# Submittal Record

Submittal #	283100.001
Cycle	1
Sub-Section	
Description	Fire Alarm
Type	Shop Drawings
Status	Open
Copies	
Subcontractor	SOUTH-FAIR ELECTRIC CONTRACTORS, INC
Contact Name	Chris Duven
Returned Due Date	12/17/2024

11.25.2024	ORIGINAL RELEASE	A
DATE	DESCRIPTION	REVISION
PROJECT:	DUNN OPERATIONS CENTER – OPERATIONS BUILDING 1269 JONESBORO RD HARNETT COUNTY N.C. 28334	
FLOOR NUMBER:	OPERATIONS BUILDING	
DRAWING TITLE:	FIRE ALARM NOTES, LEGEND & RISER DIAGRAM	
SEAL & SIGNATURE:	SHEET #:	1 OF 4
	DRAWN BY:	M.H.
	CHECKED BY:	M.H.
	WO#:	
	SCALE:	AS NOTED
	CONTACT:	
	DRAWING NO.:	<b>FA-001</b>

1000 N. MAIN ST., STE. 201  
FUQUAY VARINA, N.C. 27526  
Ph. 919.346.4630  
NC LICENSE #: SP.FA/LV.31726

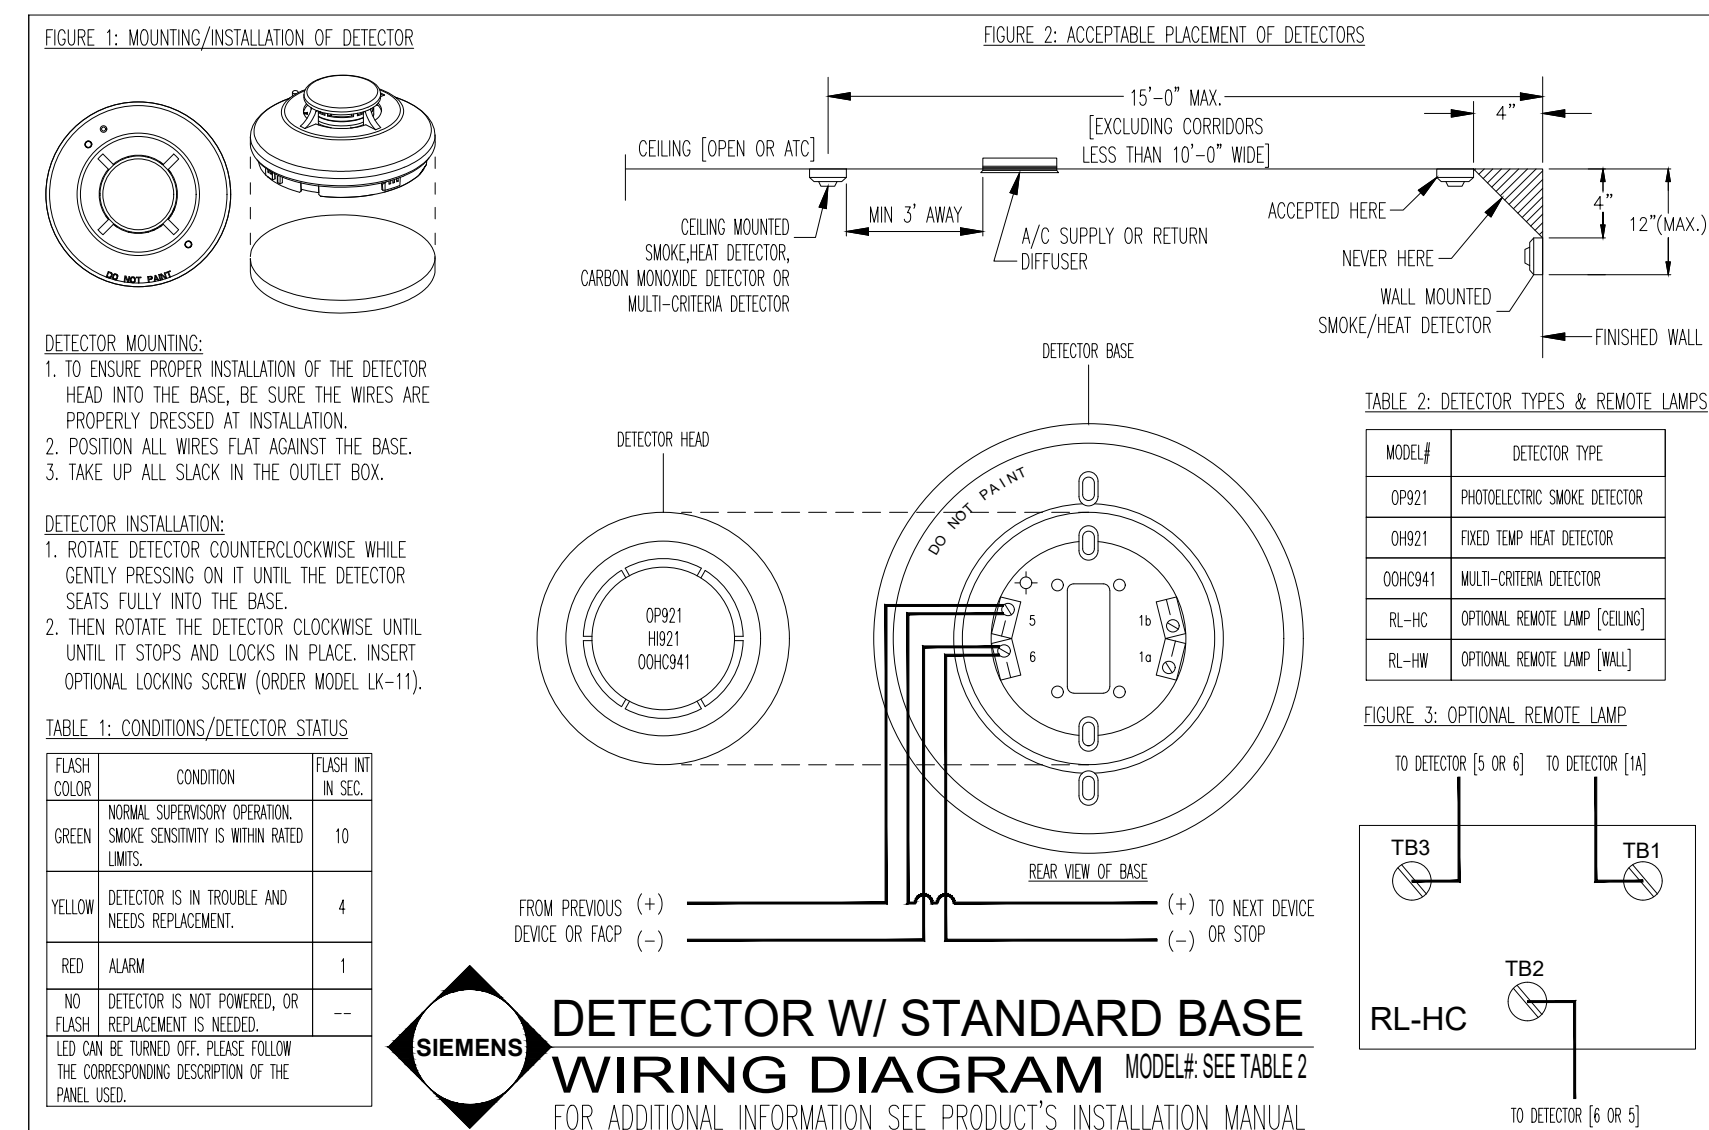
BWA(AMR): LOCATE SMOKE DETECTOR ABOVE ELECTRICAL GEAR.
